ITEM 1.3(d)

Issue/ Objection:  
Natural Ventilation

PROJECT		85 Harrington Street The Rocks GOLDEN AGE & HANNAS THE ROCKS	
TITLE		RESPONSE TO DoPE ITEM 1.3(d)	
SCALE	1:200 @ A2	PROJECT CODE	
DATE	18/10/2017	GA85H	
SHEET NO.	014	REVISION

COMPLIANCE
 29 APARTMENTS ACHIEVE ADG COMPLIANCE
 14 APARTMENTS ACHIEVE NATURAL VENTILATION AS DETAILED IN REPORT BY ARUP
 TOTAL: 43 OUT OF 56 APARTMENTS = 77%

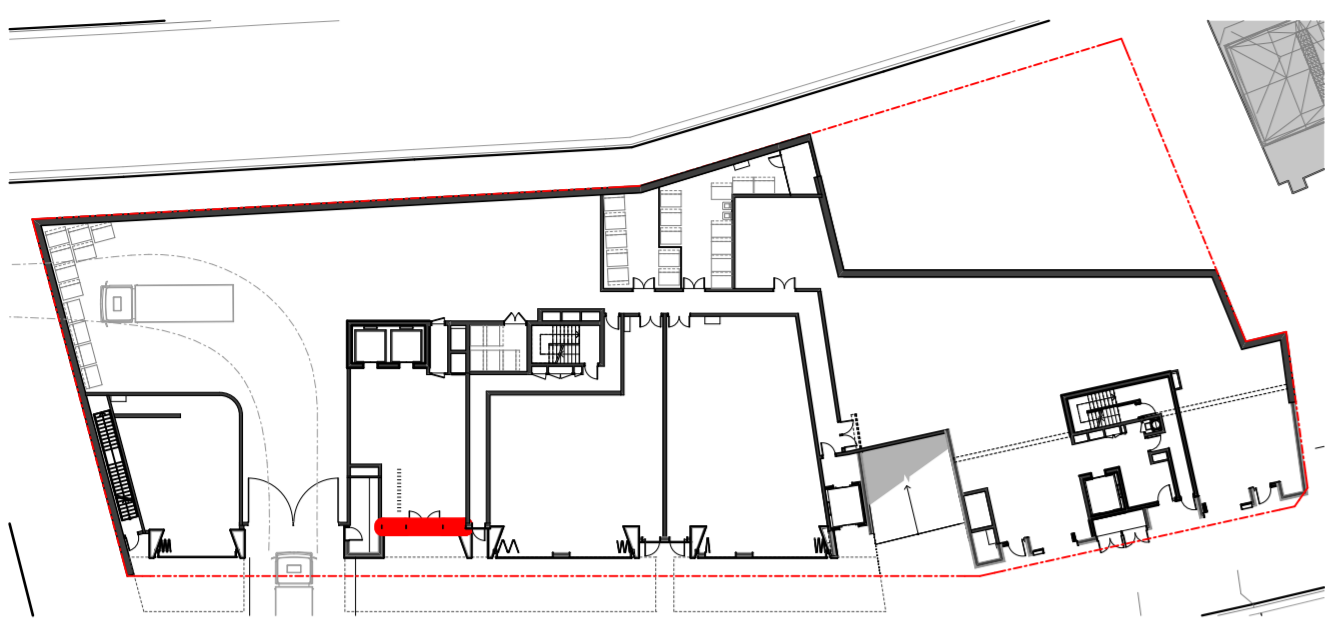
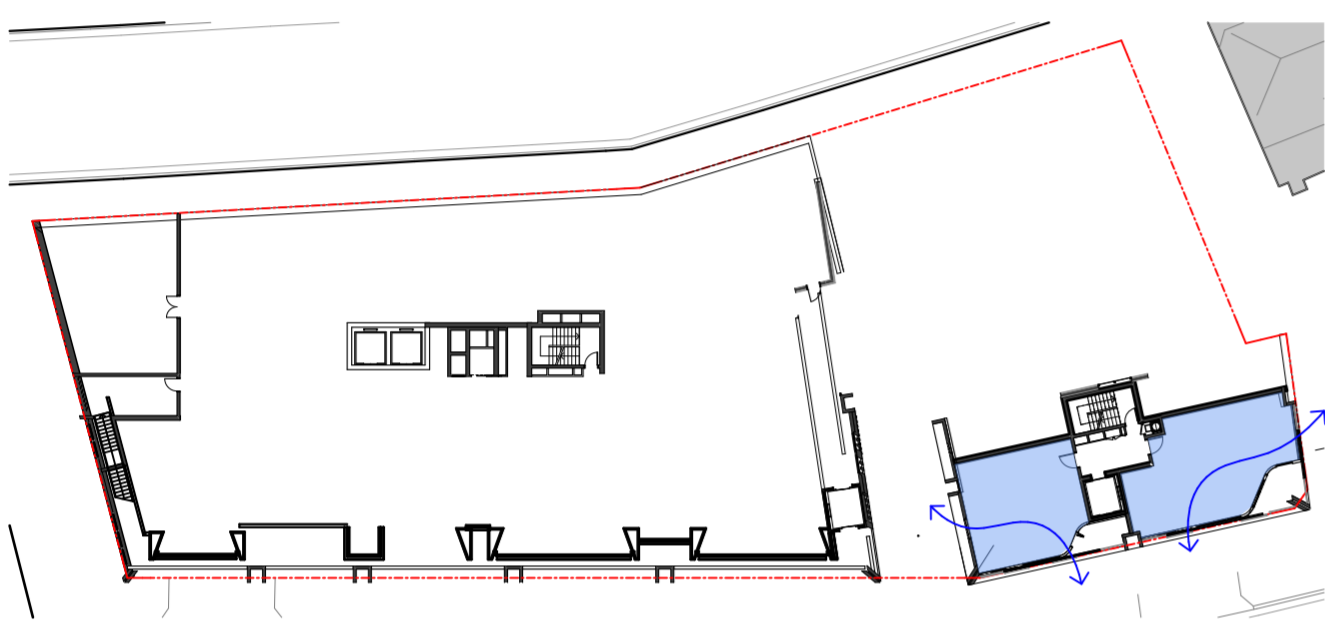
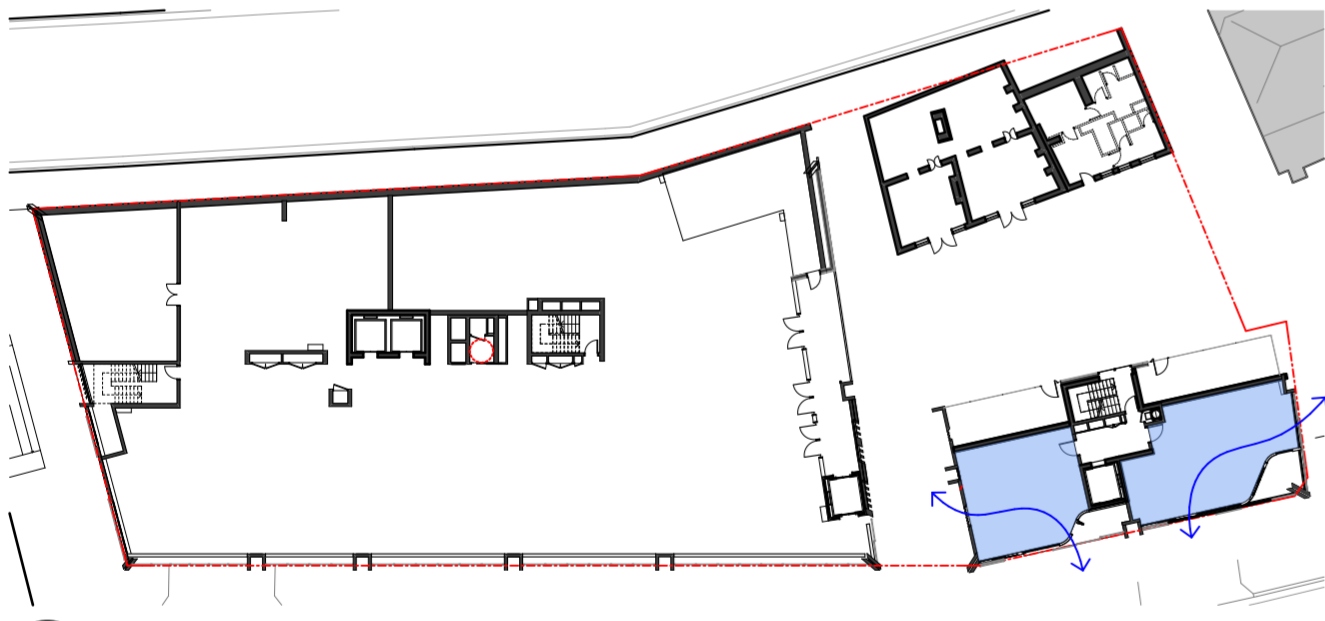
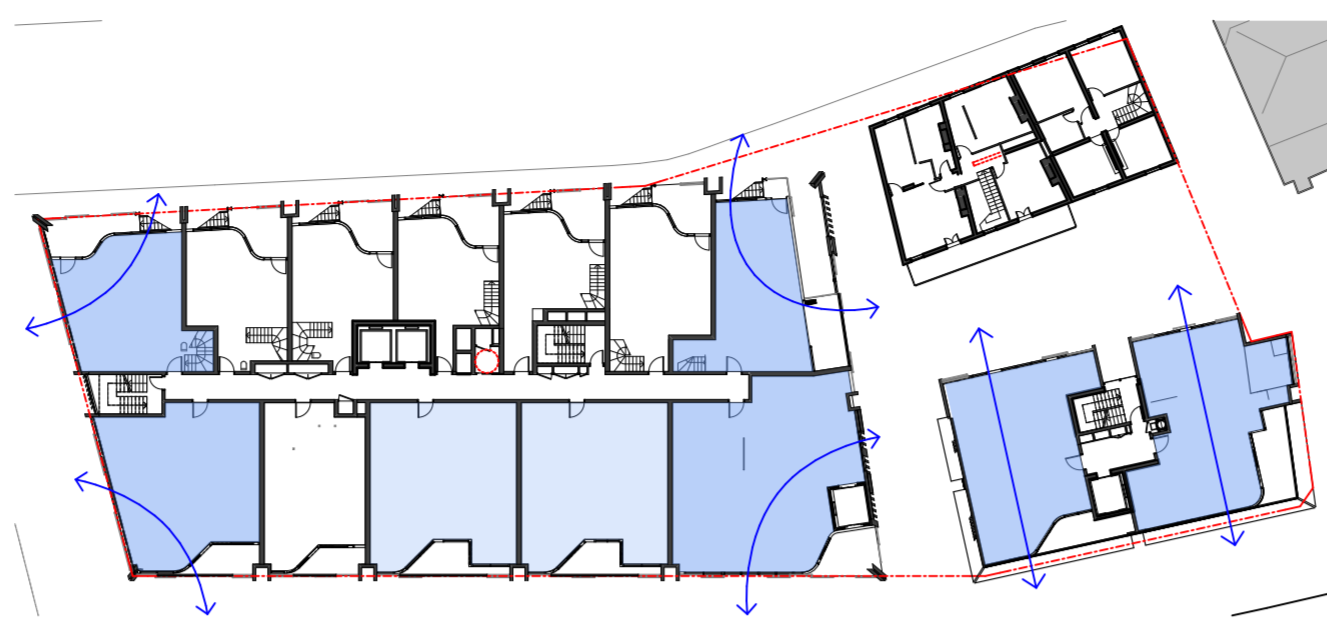
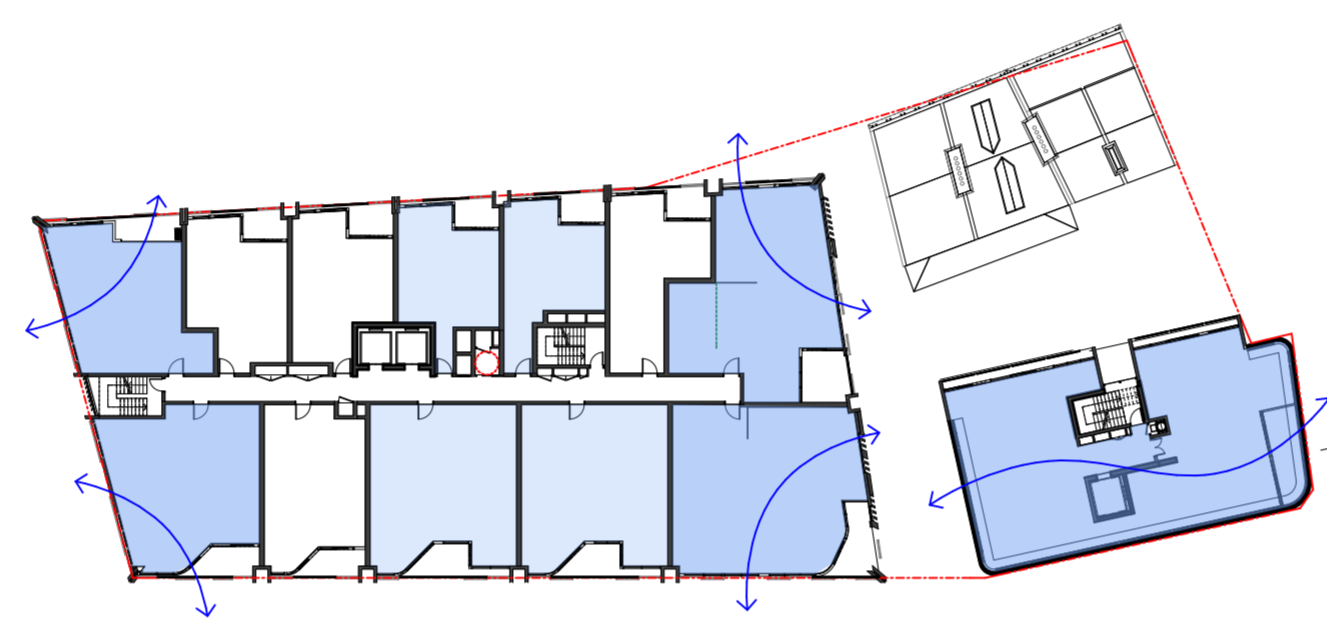
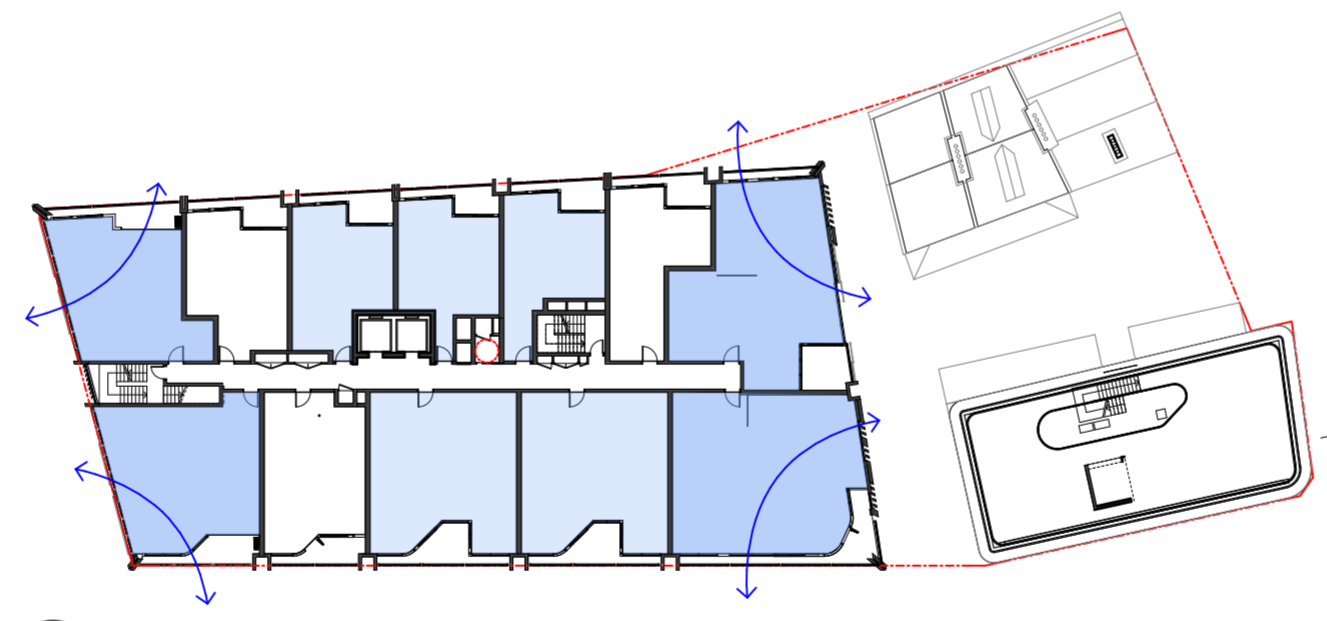
Description:  
The proposal includes the five single aspect maisonette units as achieving natural cross ventilation. Further evidence is required demonstrating how these units achieve natural cross ventilation. Consideration should also be given to alternative dieting solutions for non-cross ventilated units to improve natural ventilation.

Response  
29 Apartments achieve compliance as per the apartment design guide's (ADG) definition of natural cross ventilation. 5 Apartments achieve cross ventilation as detailed in qualitative assessments undertaken by ARUP. Refer to all additional information prepared by ARUP.
